Drafted 18 May 2012

**Planning Application, Ribble Valley District
3/12/0270 18 King Street, Whalley**

I am recommending refusal of this application on highway safety grounds.

PROPOSED GROUND FLOOR PLAN / SITE PLAN
SCALE 1:50

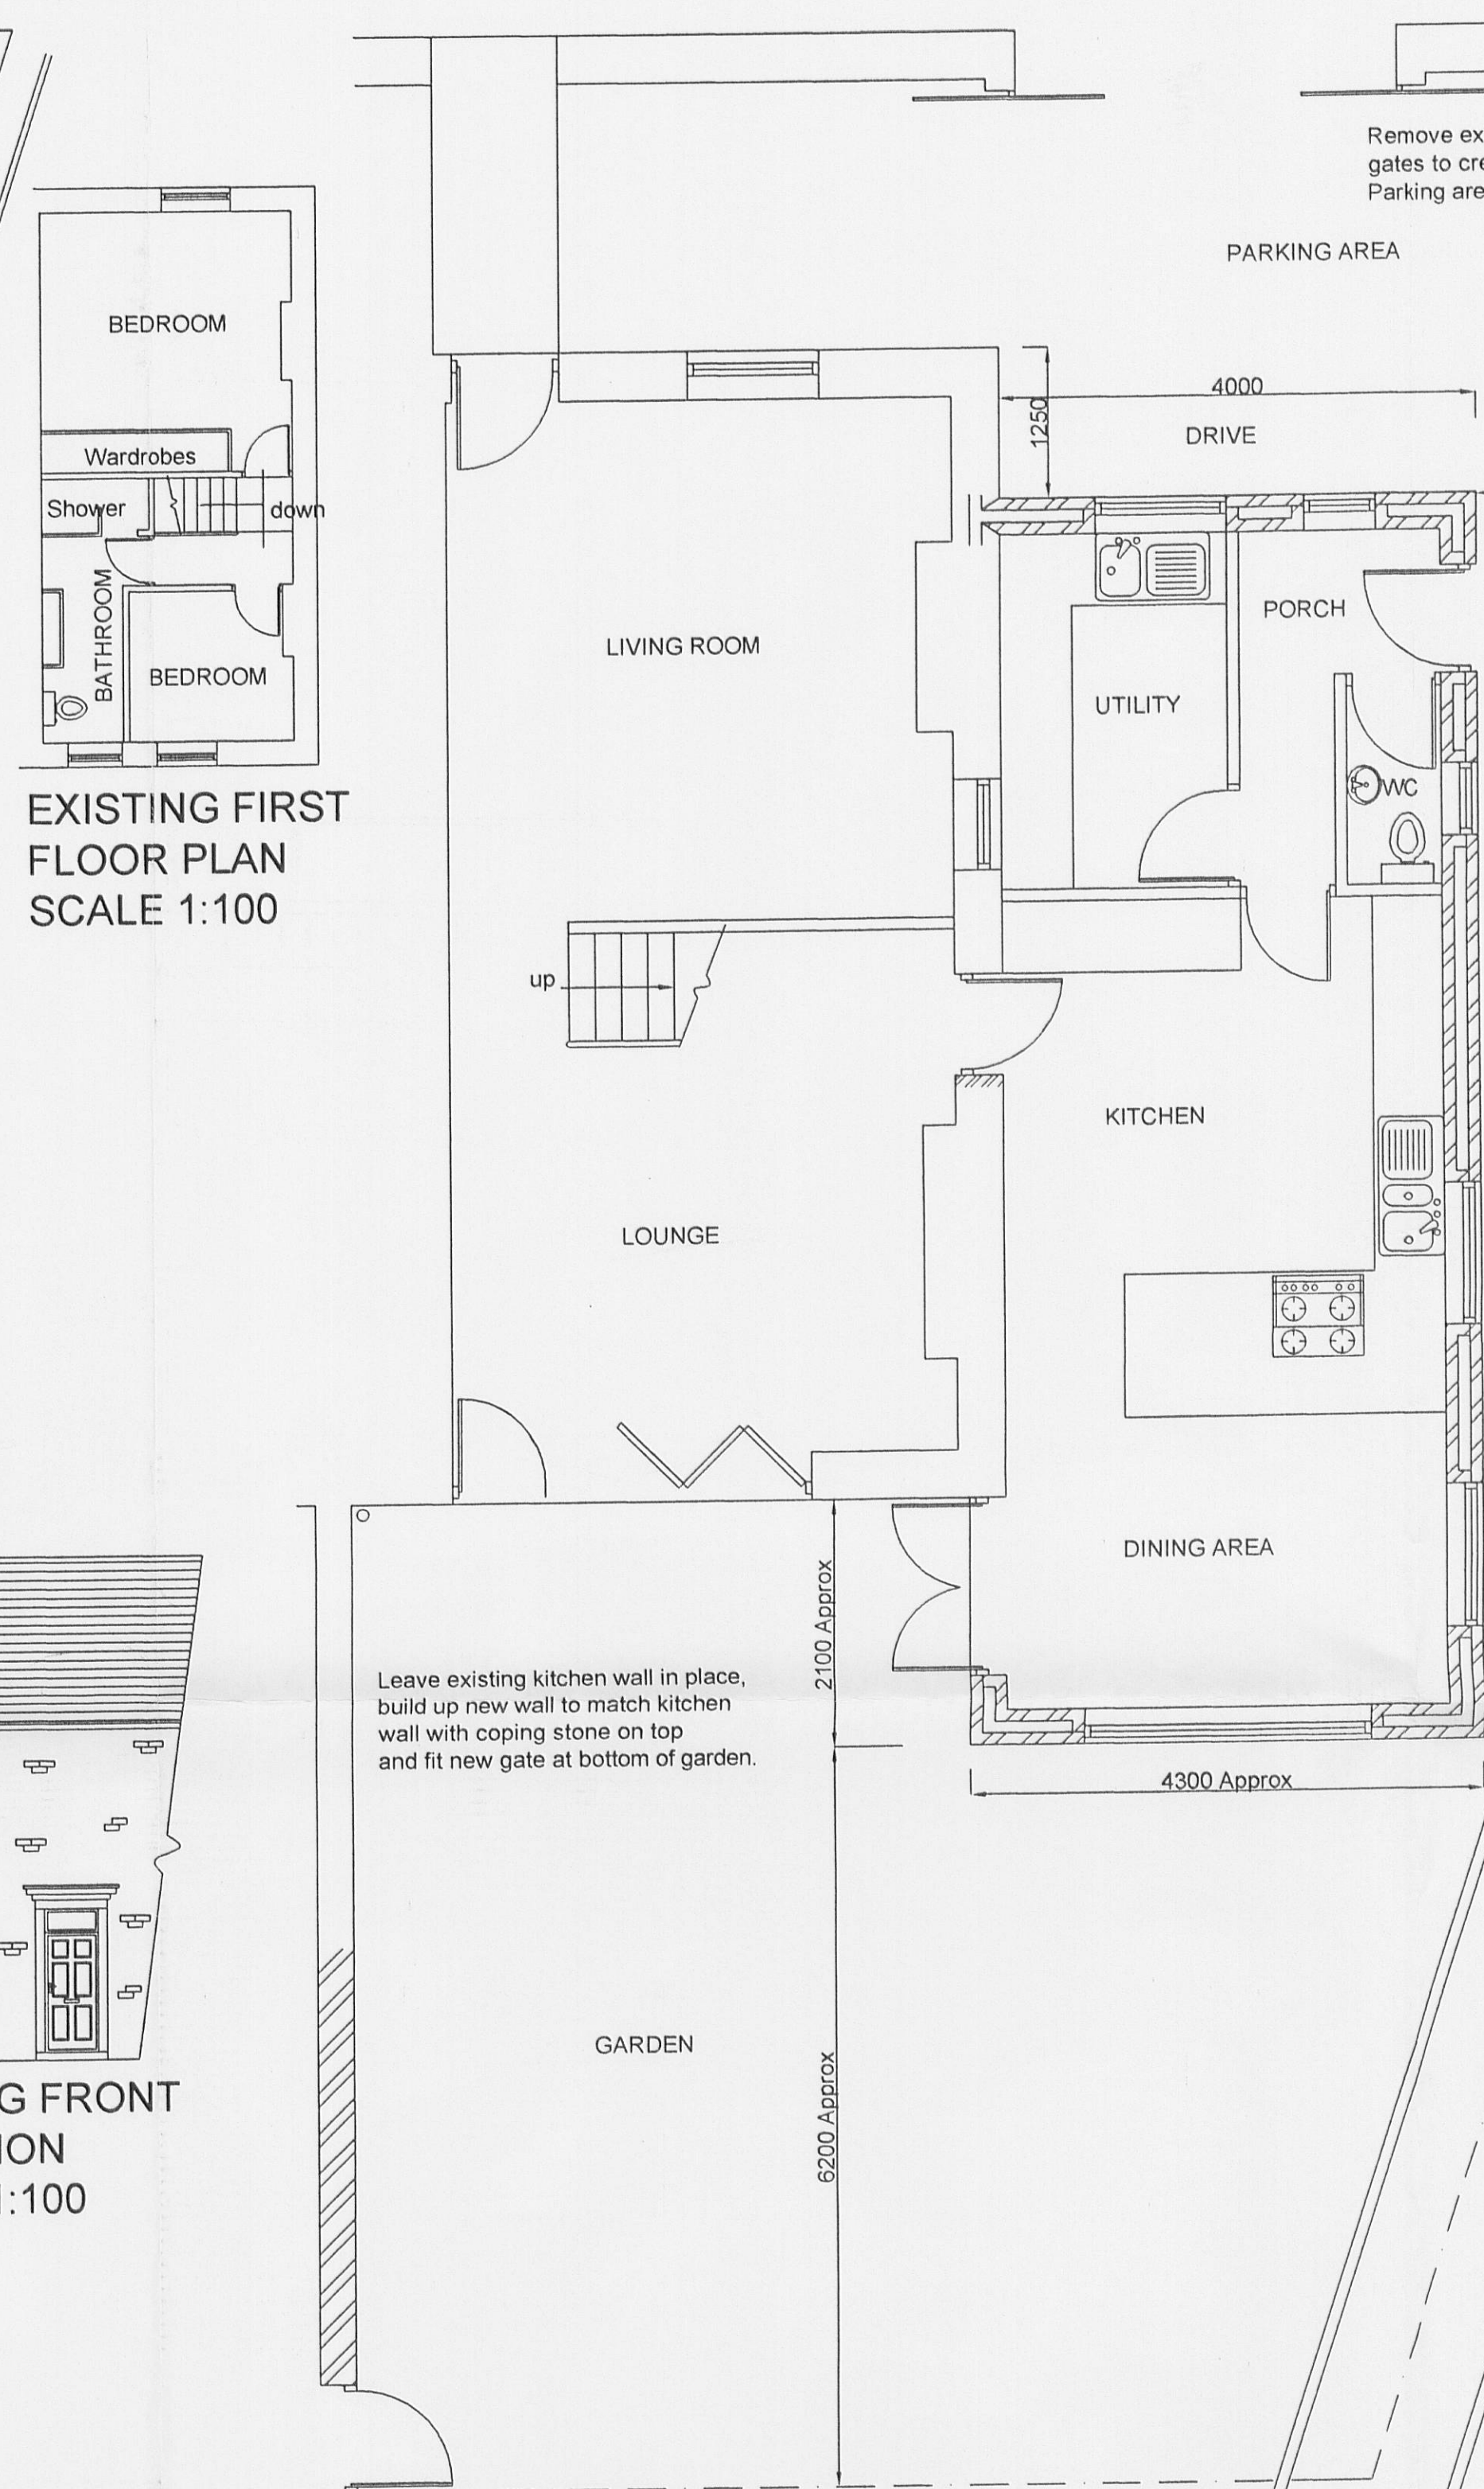
The proposed alterations to the property and the resulting changes to the layout does not provide the opportunity for vehicles to access the site in the same manner as exists at present, a situation exacerbated by its sensitive location on King Street where on street parking can have a significant impact on the safe and effective movement of through traffic.

While the operation of the gate has been altered, the changes in the footprint of the property make it unclear how the site can accommodate off street parking for three vehicles, the level of provision consistent with the anticipated requirements of a four bedroom residential property.

Therefore, on the basis of the potential negative impact of the revised parking arrangements at this site, with reversing manoeuvres to/from the highway at a sensitive location, I am recommending that this application be refused on the grounds of highway safety.
